NSIP Reference Code: TR010065

Natural England's comments in respect of the A46 Newark Bypass

Natural England's Relevant Representations

Version	Date	Status of Version
Rev 1	April 2024	DCO Application

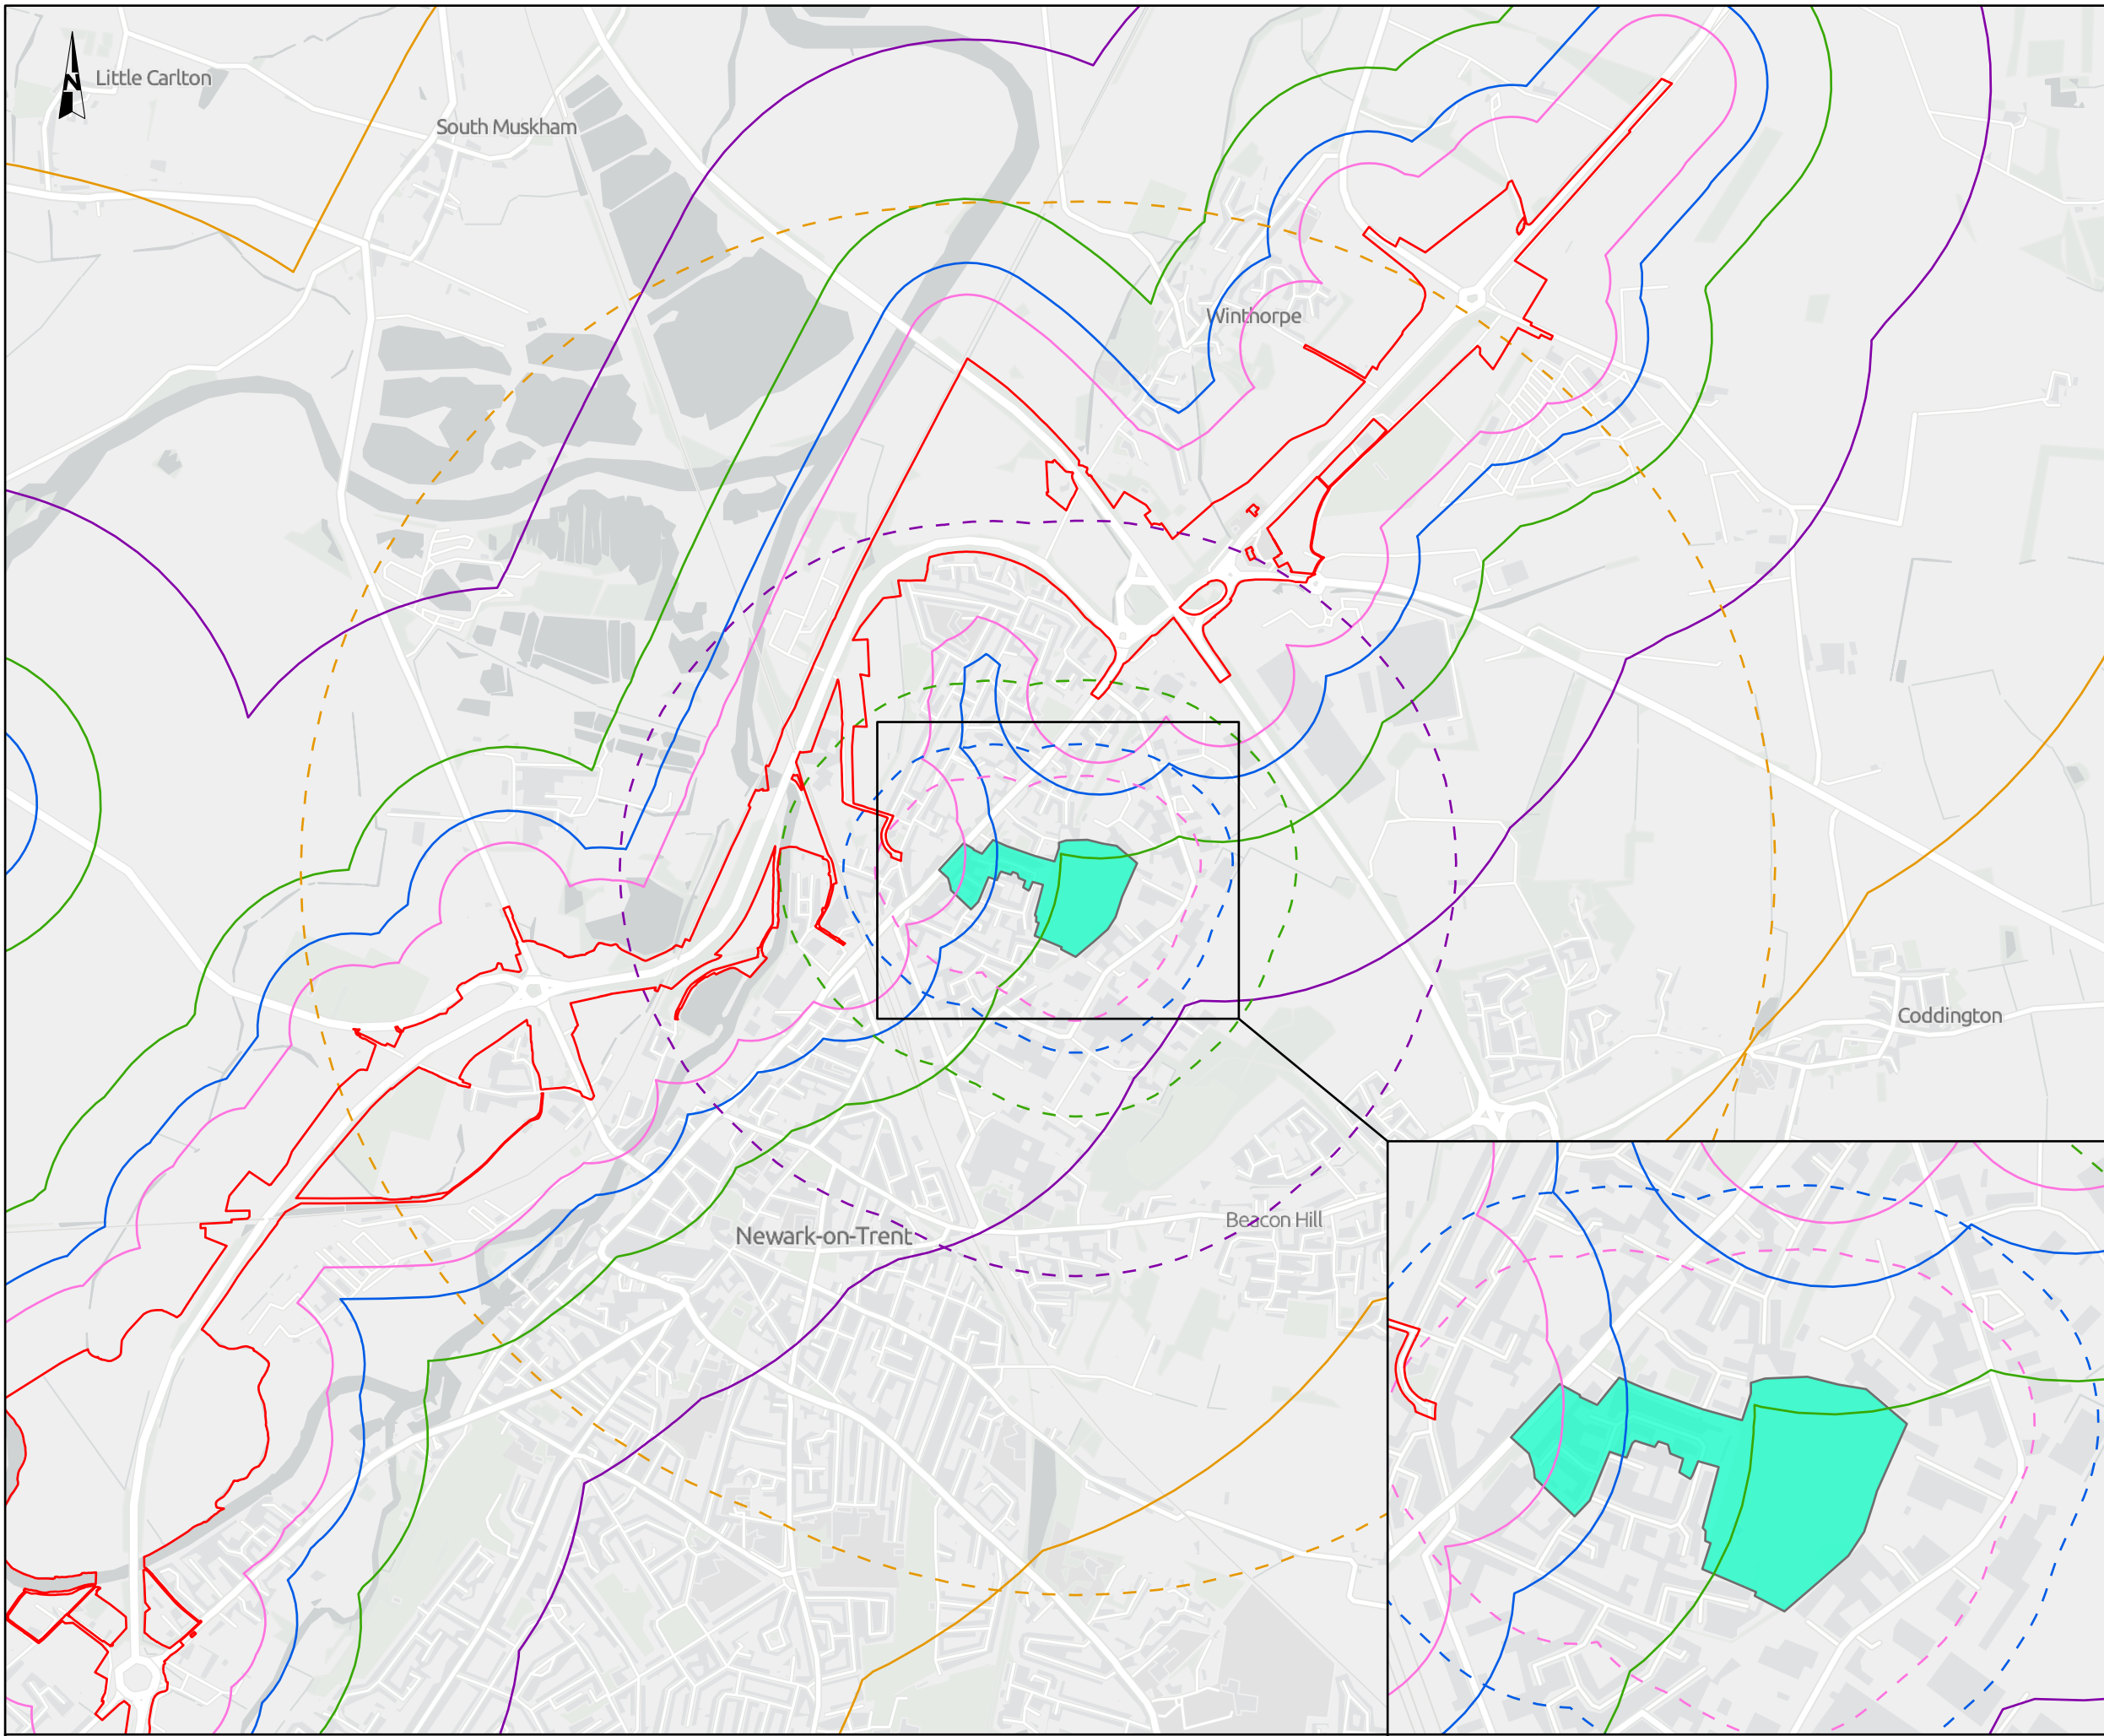
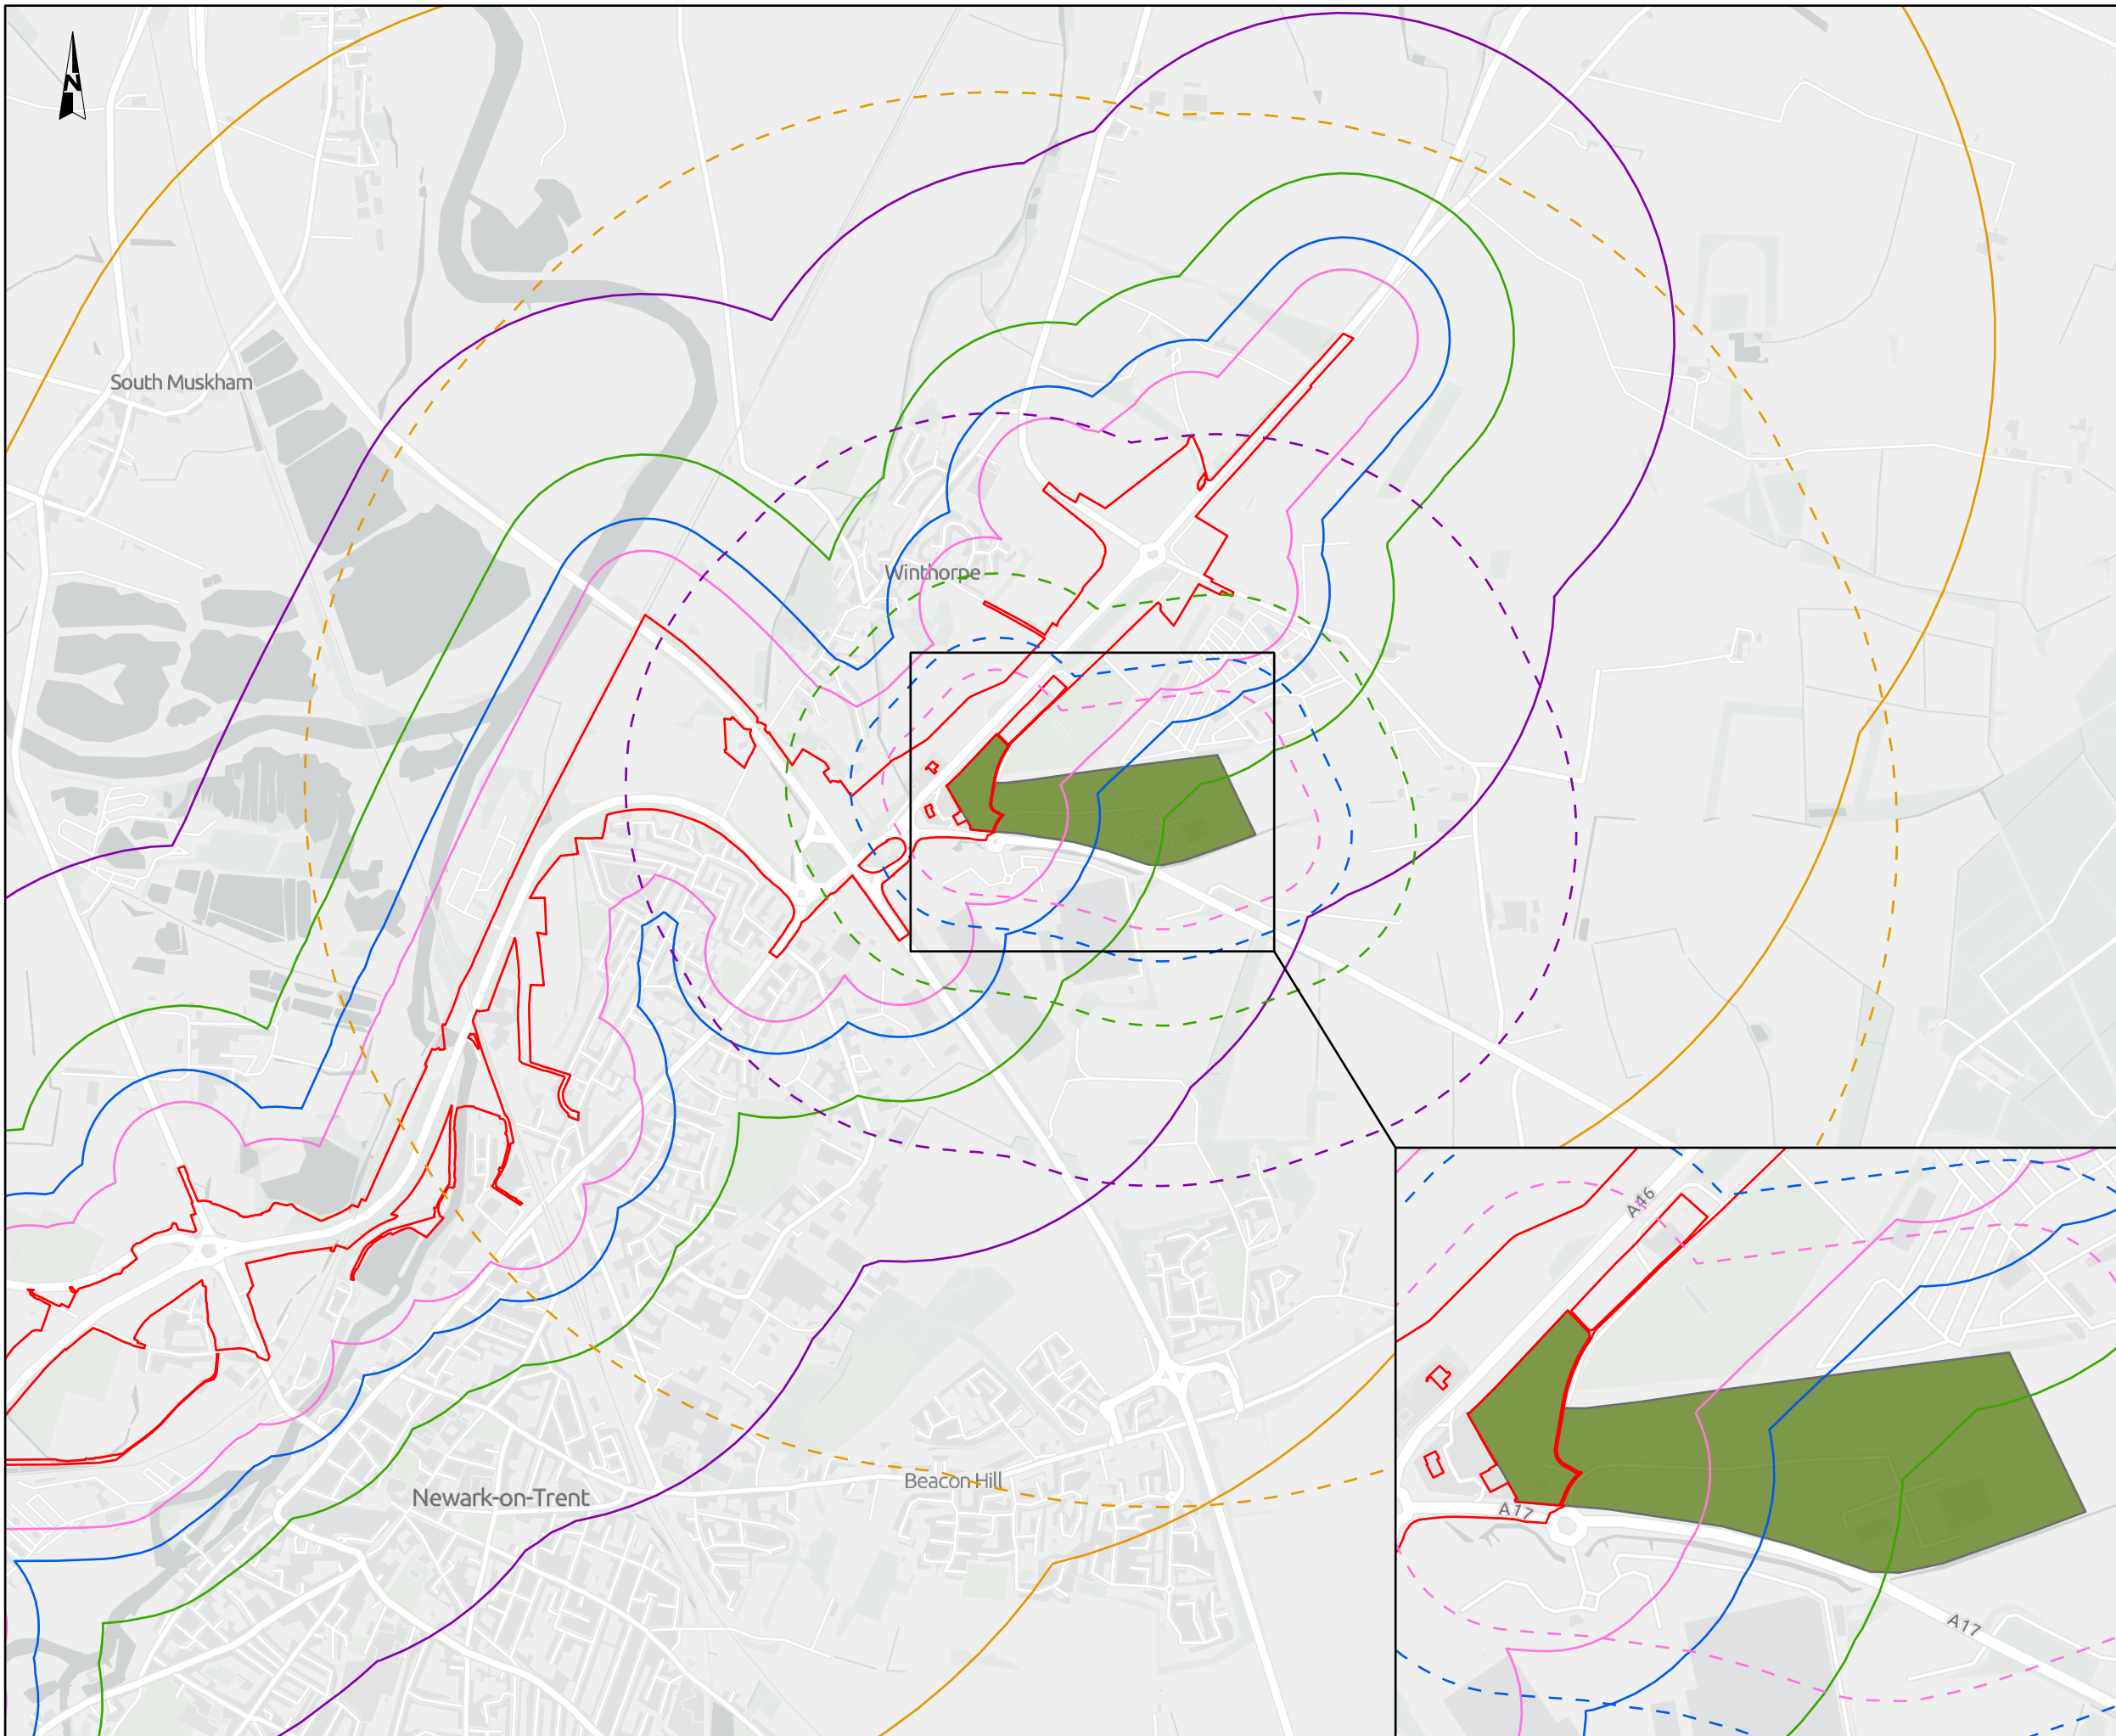
NE5	International designated sites <ul style="list-style-type: none"> • Humber Estuary SAC • Humber Estuary Ramsar 	HRA screening in-combination: Assessment of scheme location criteria (Construction and operational phases)	<p>Within the HRA in-combination assessment table (Stage 1: Screening; p40-48), projects are listed by distance from the SAC/ Ramsar. It is suggested that distance from the project is also an important factor for consideration. This is due to the River Trent's functional linkage to the designated sites, therefore in-combination effects of projects upstream of the Humber Estuary have the potential to impact the international sites.</p> <p>It is recommended that a further review is undertaken to ensure no further projects located close to the development require assessment.</p>	Further information required.	Amber
